**Your Ref:** OWPC17520  
**Our Ref:** FG/115/17/PL  
**Please ask for:**  
Mrs A Gardner

4 No. bungalows  
44 Ferringham Lane Ferring

Thank you for your internet comments made on 6th March 2018 which has been recorded as **'an objection'** with the comments as follows:

Site section (east-west)

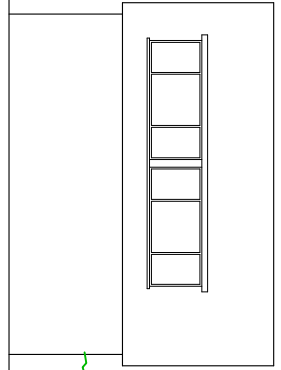
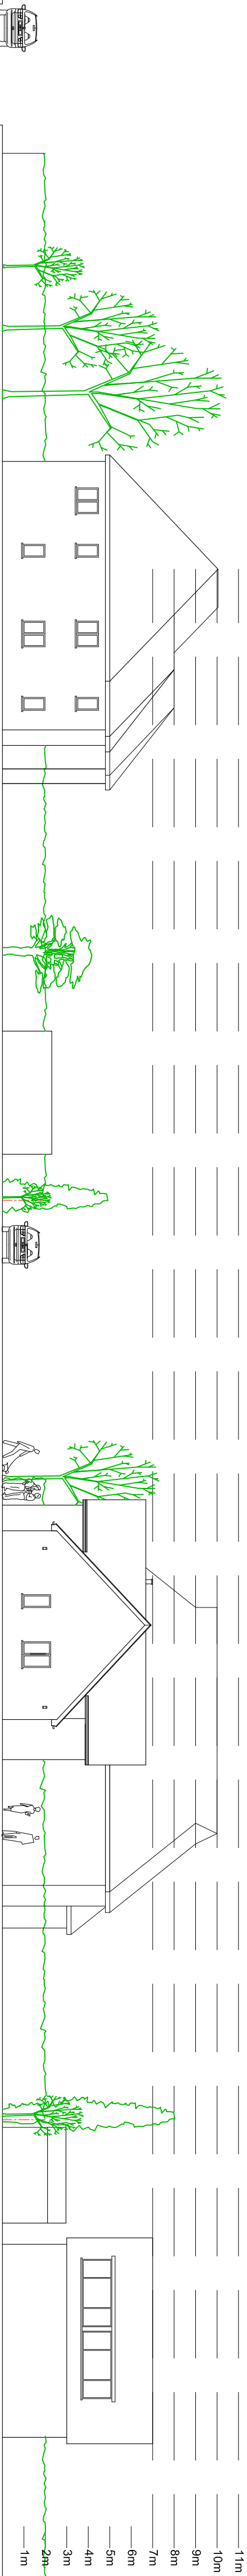
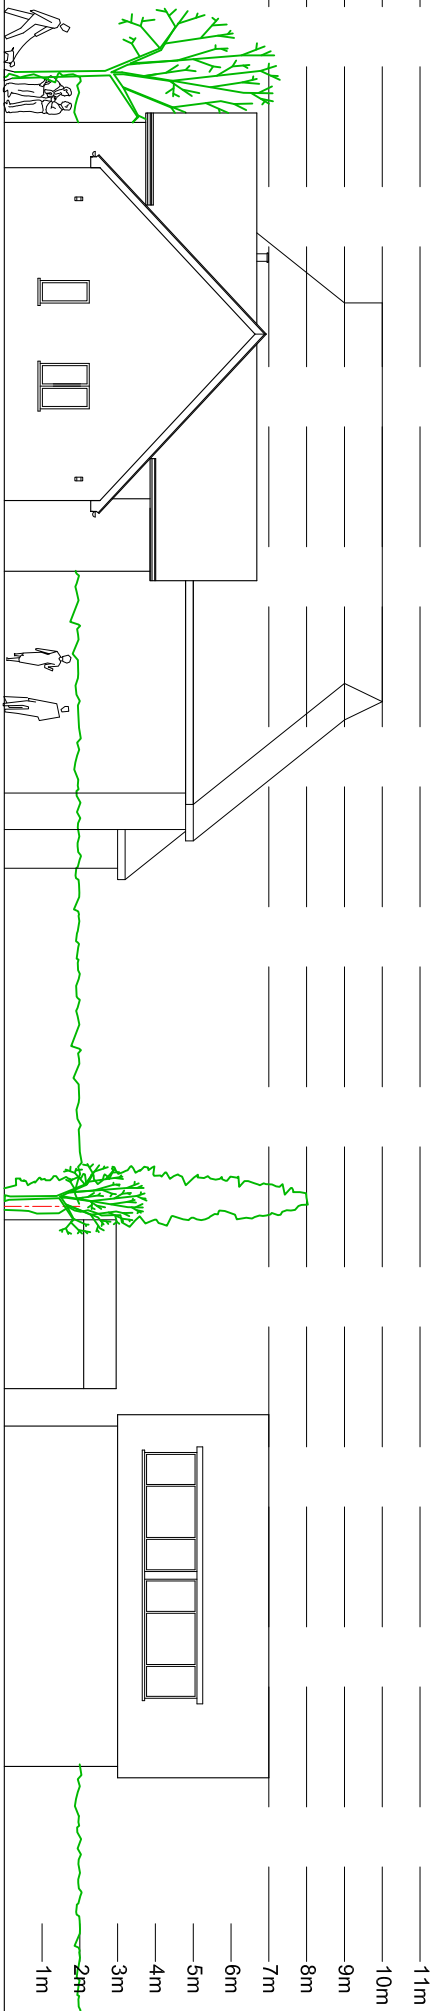
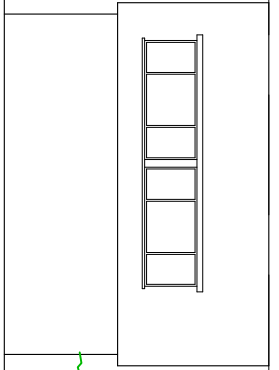
*Ferring Parish Council appreciate that outline planning has already been granted on appeal, however this revised stature of the properties will still have an overbearing impact on neighbouring properties who will lose their privacy and undoubtedly experience additional noise. This is still an over-development of the site and out of keeping with the area.*
